## Community Services Planning Department

**RESPONSE TO COMMENTS MAY 26, 2020**

Reference: Aspen Ranch Construction Plans  
Generally located Northeast of the Intersection of Link Road and Kane Road

I have completed the initial review of the Construction Drawings for Aspen Ranch. The following are items that need to be corrected and/or modified. Once all revisions have been addressed please submit 3 full size drawings. If additional agency comments are received, they will be forwarded to you for review and comment.

DT03

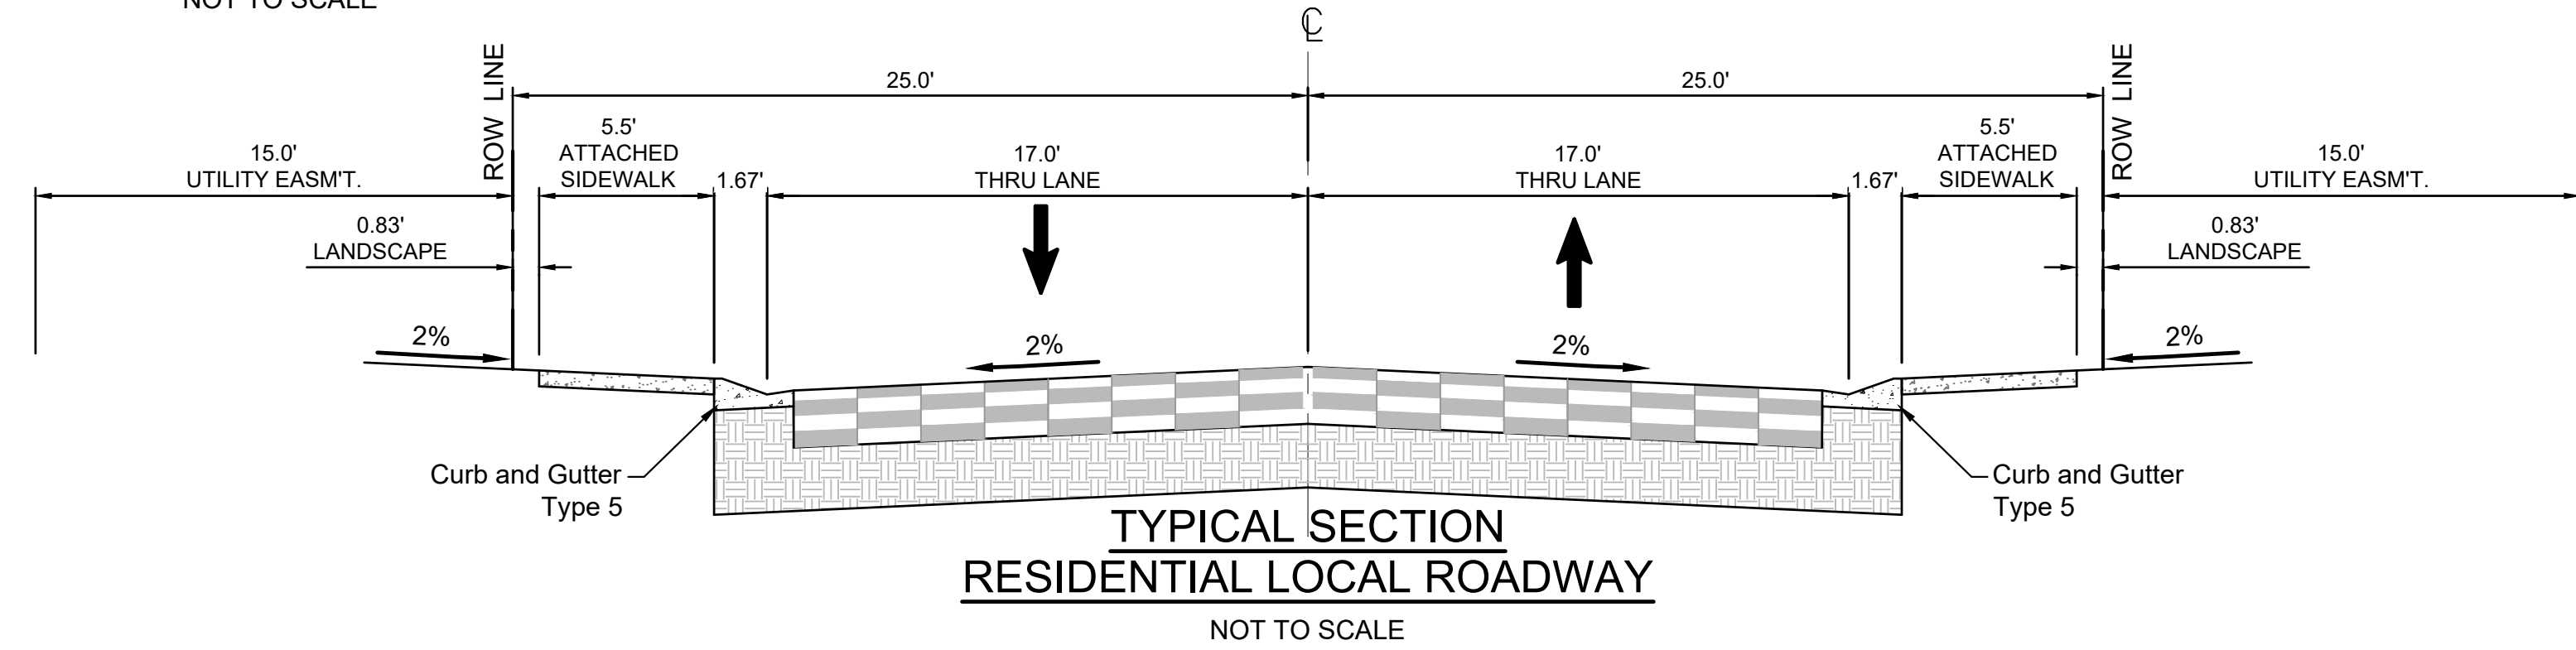
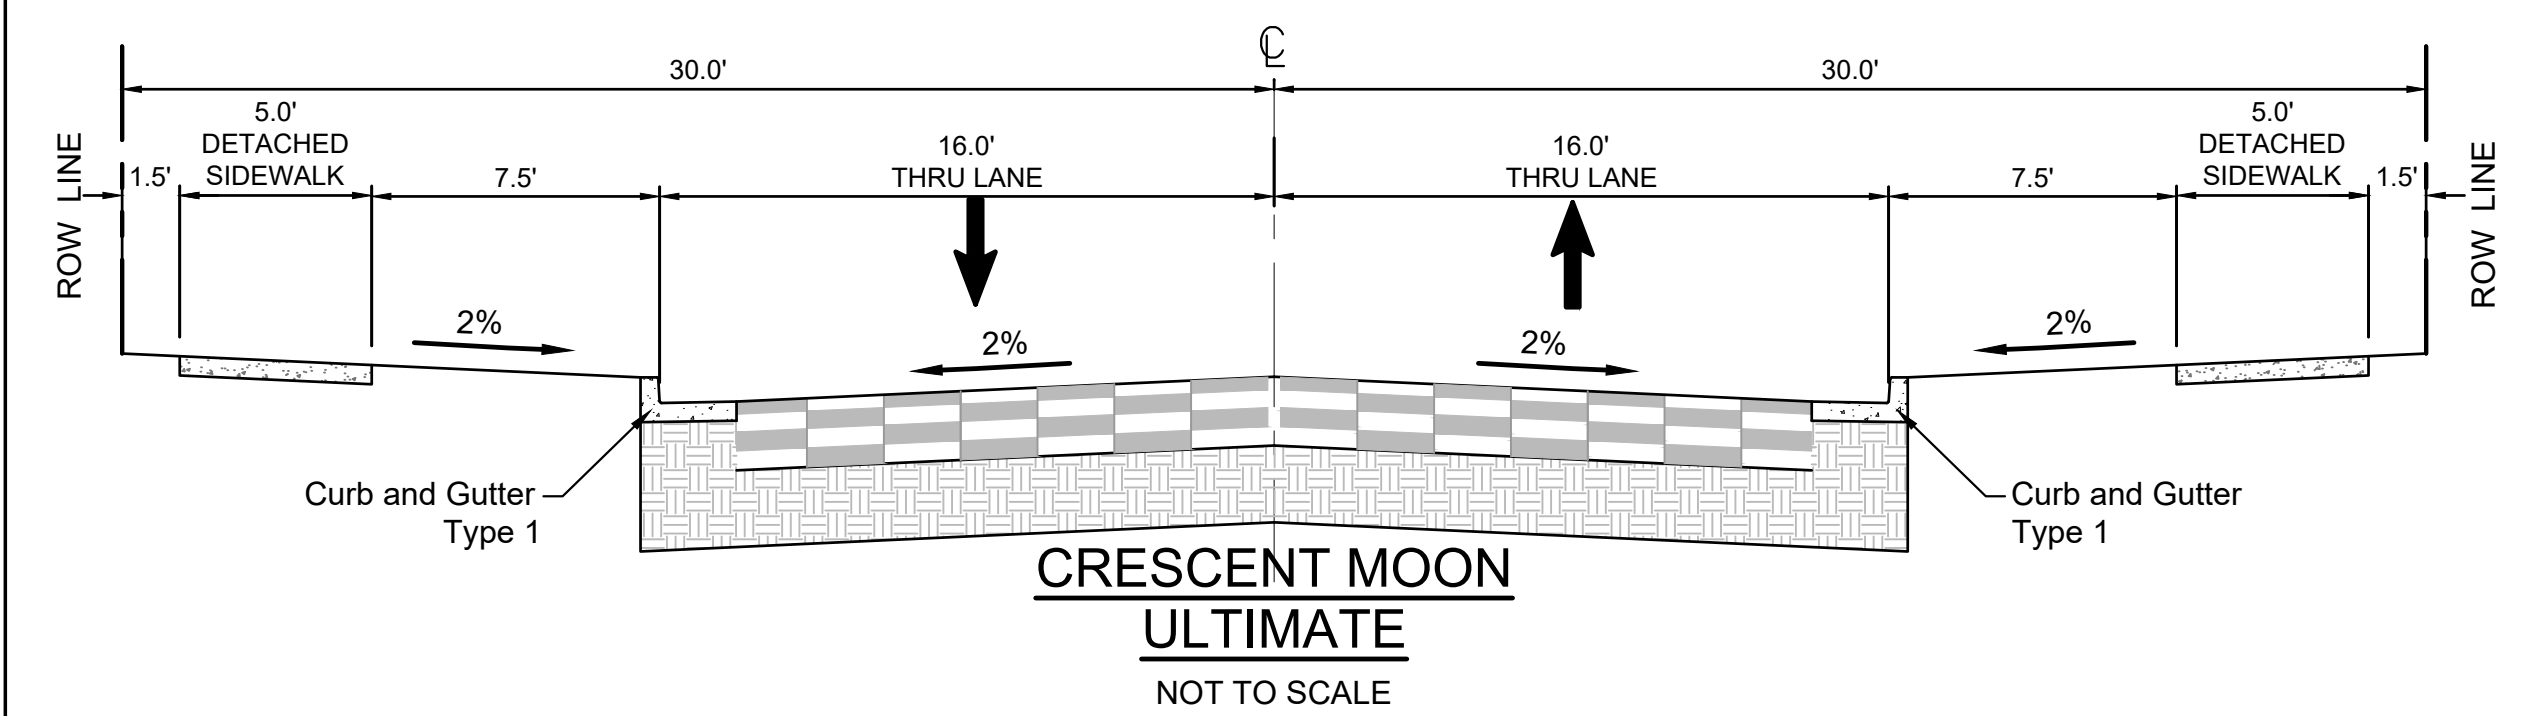
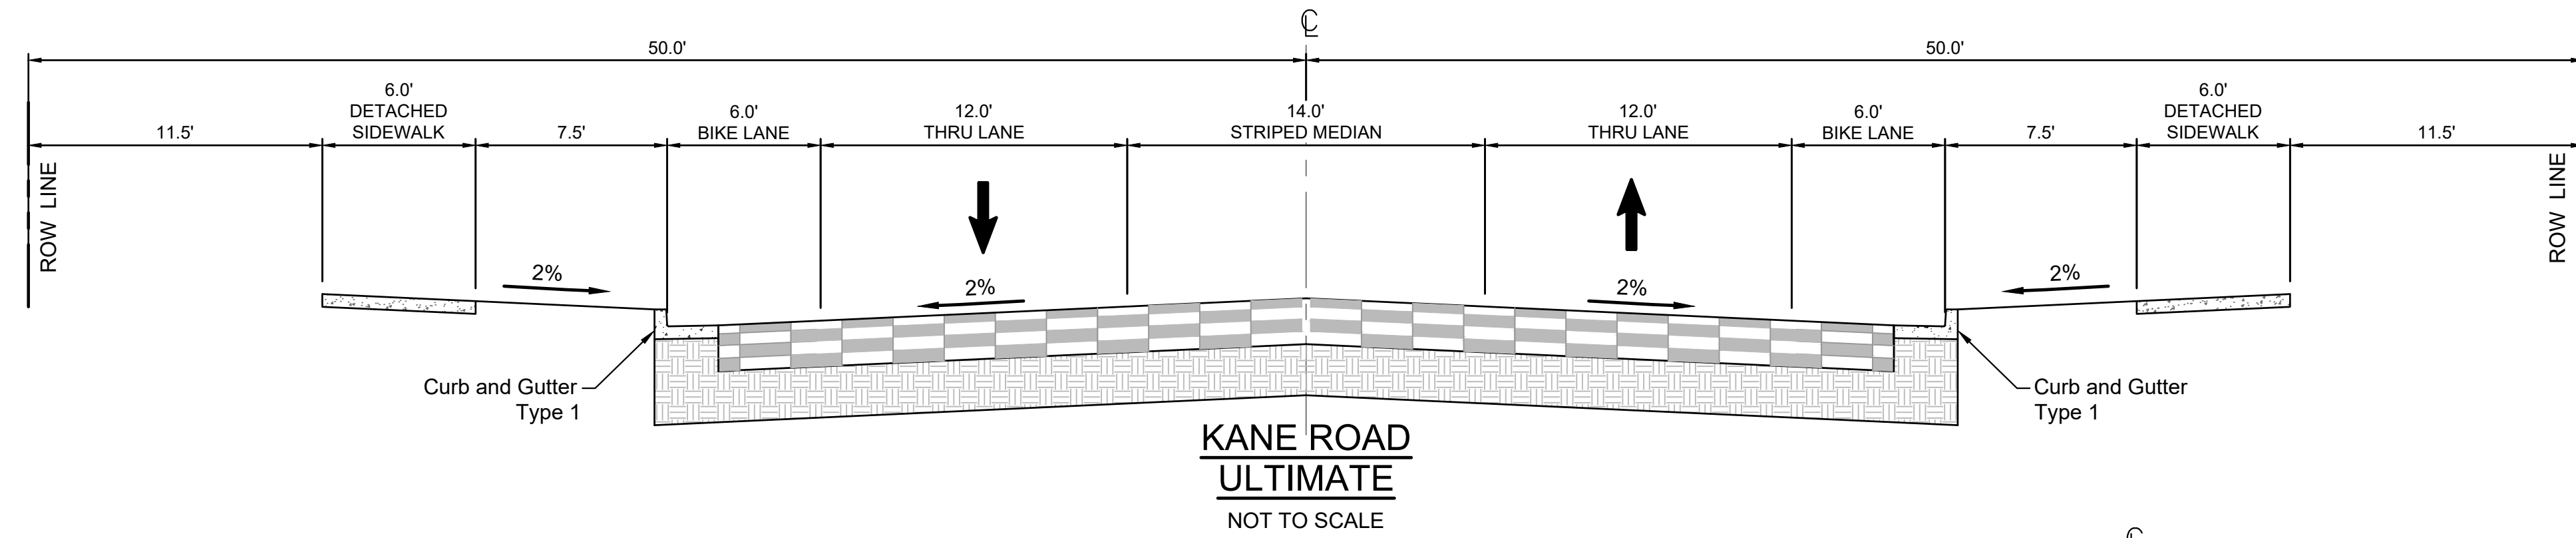
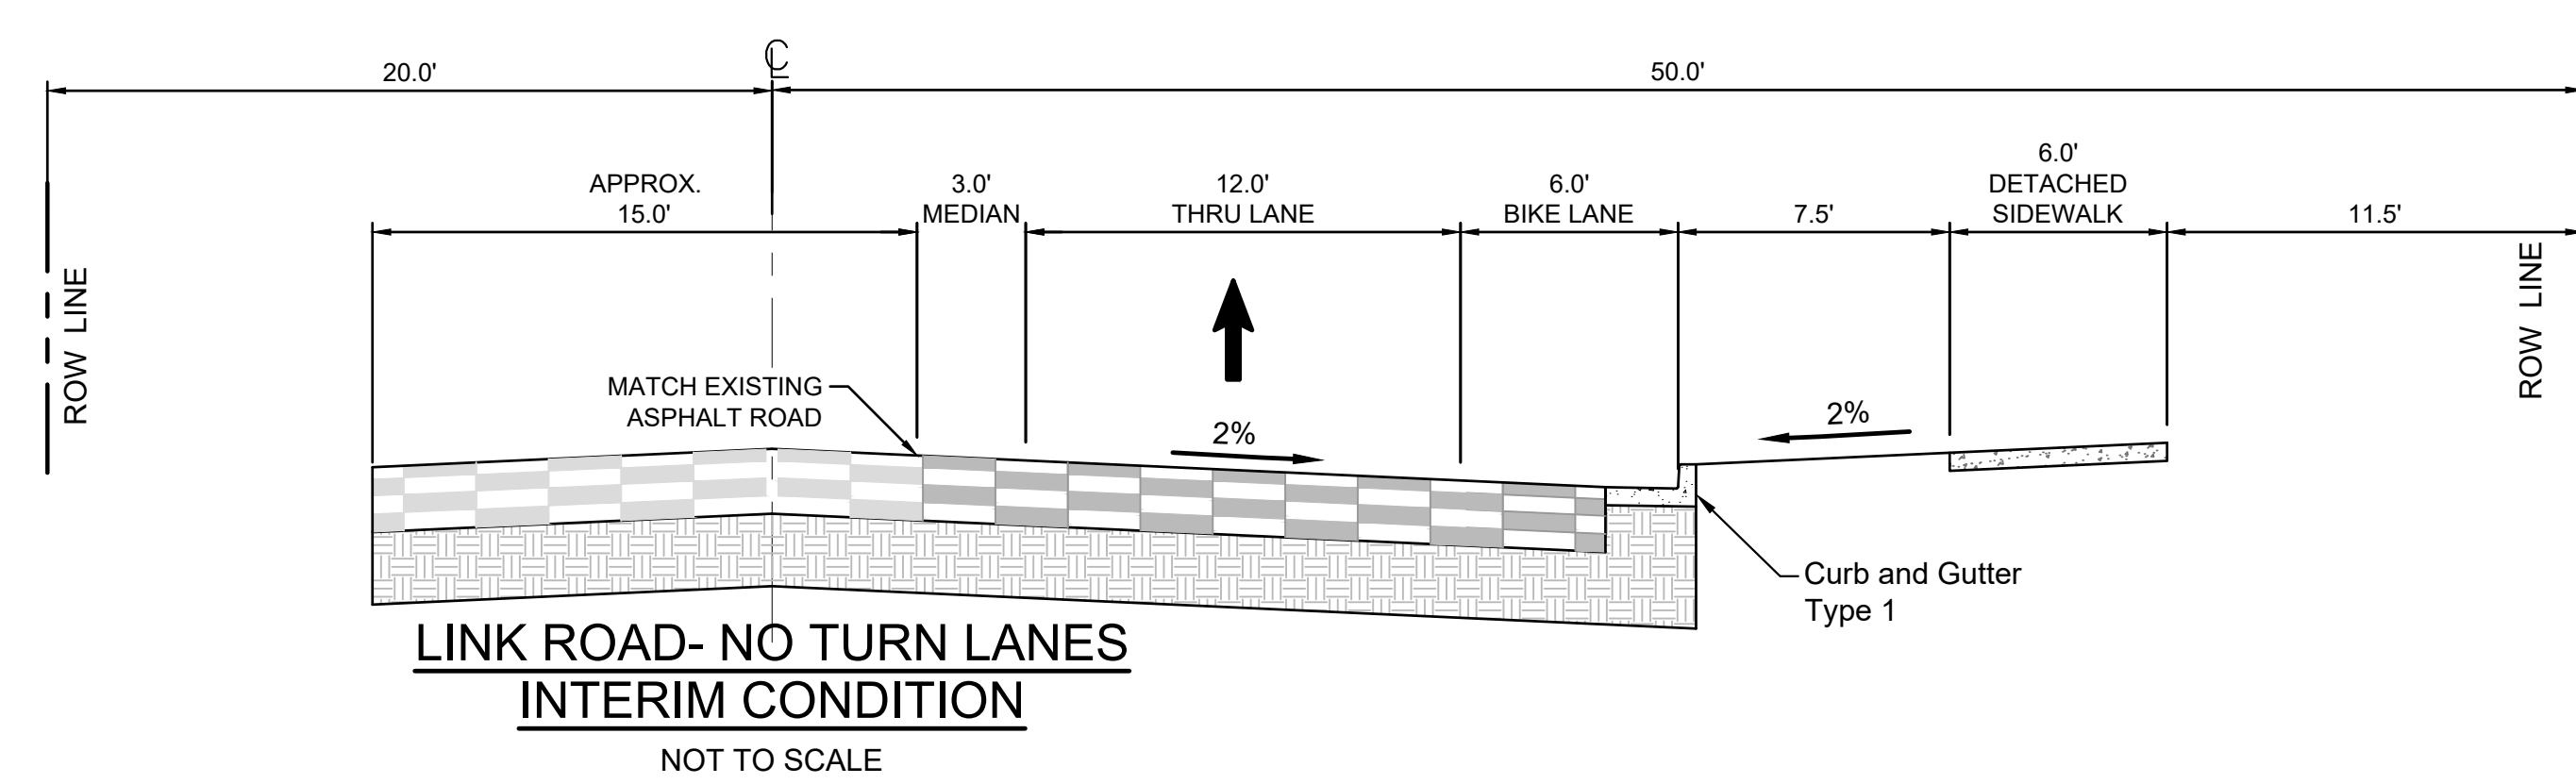
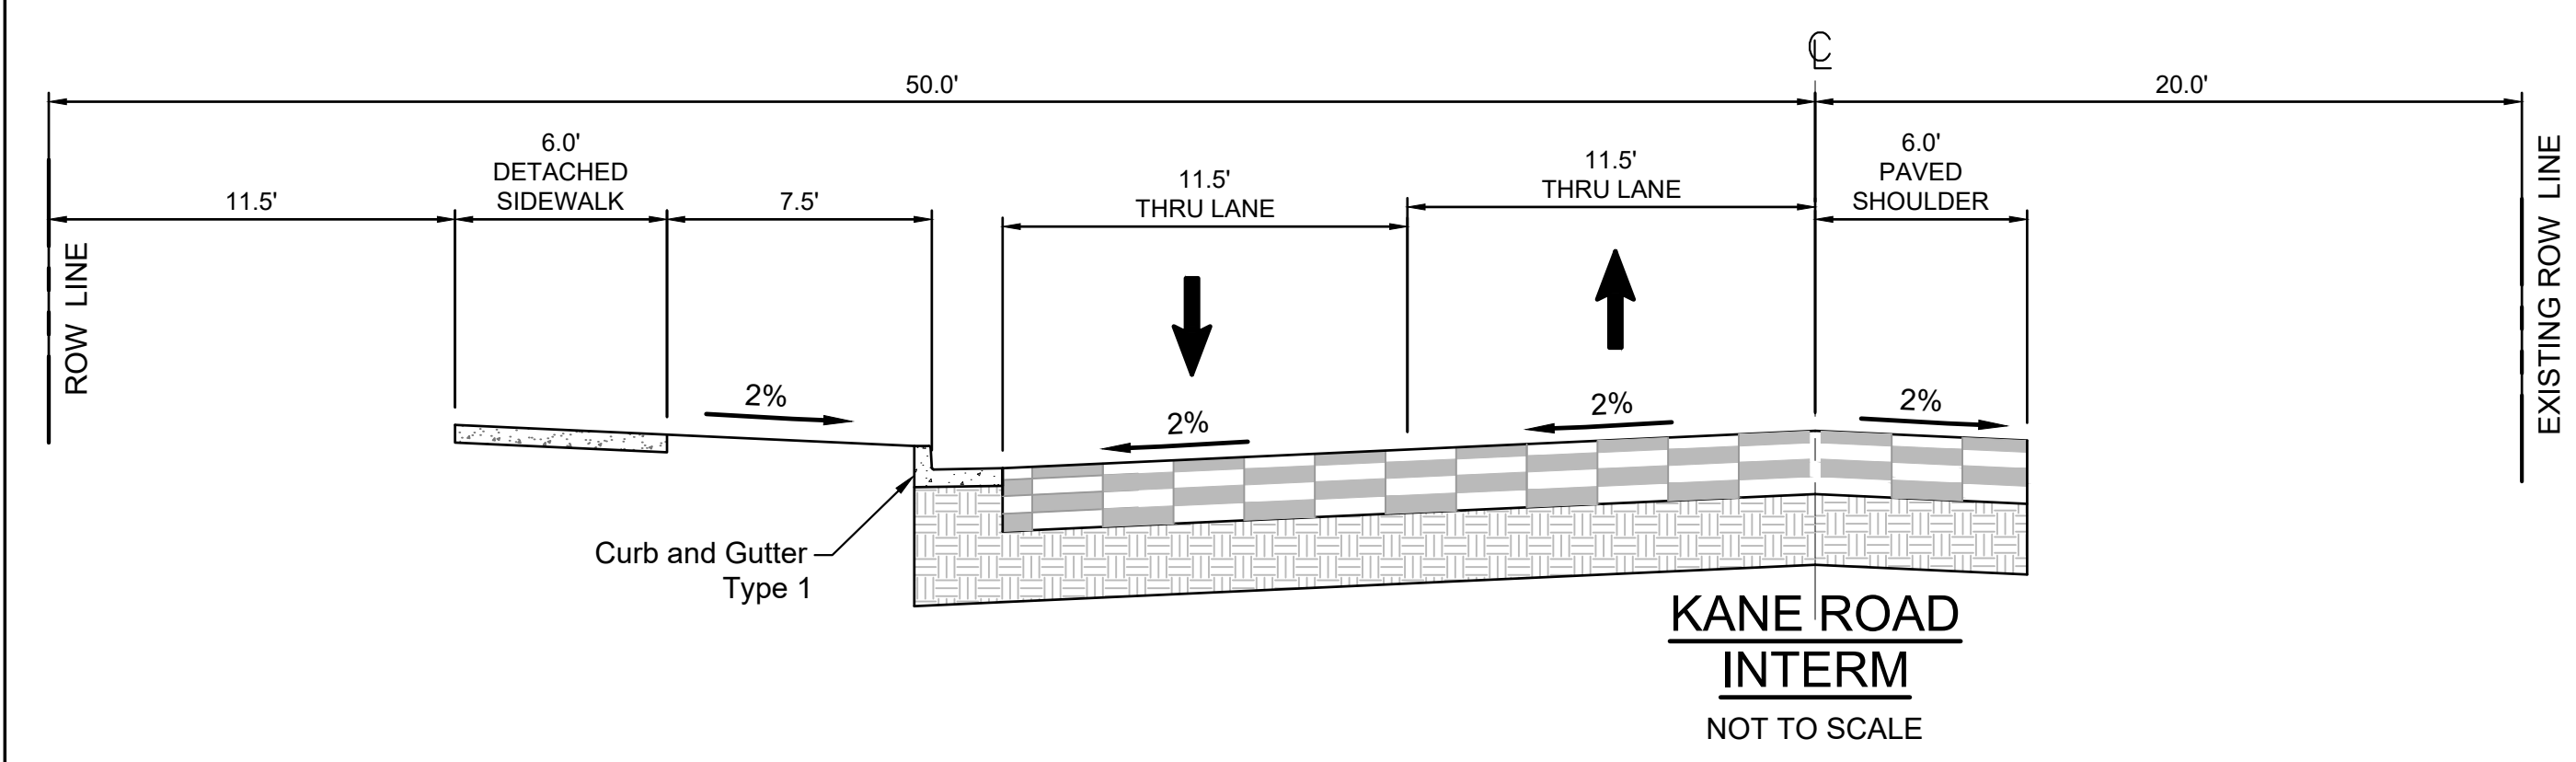
2. Please revise the LINK ROAD – NO TURN LANE INTERIM CONDITION cross section. The City of Fountain Phase 4 project for Link Road will **move** the centerline of Link Road to the Section Line at the intersection of Watchmen Road and between Watchmen Road and Squirrel Creek Road. The Aspen Ranch development is to **move** the centerline of Link Road to the Section Line; please revise the cross section accordingly. Also, this portion of Link Road is to be milled and overlaid. Please email with any questions. **RESPONSE: LINK RD. CROSS SECTION UPDATED ON DT03 AS REQUESTED.**

10. The Kane Road ultimate cross section should match the Link Road ultimate cross section. **RESPONSE: KANE RD. CROSS SECTION UPDATED ON DT03 AS REQUESTED TO MATCH LINK RD. LINE WORK ON PRELIM PLAT ALSO UPDATED.**

11. Revise the Kane Road Interim cross section to have 23' of asphalt from centerline to lip of pan and 6' of asphalt on the other side of centerline. **RESPONSE: KANE RD. CROSS SECTION UPDATED ON DT03 AS REQUESTED TO MATCH LINK RD. LINE WORK ON PRELIM PLAT ALSO UPDATED.**
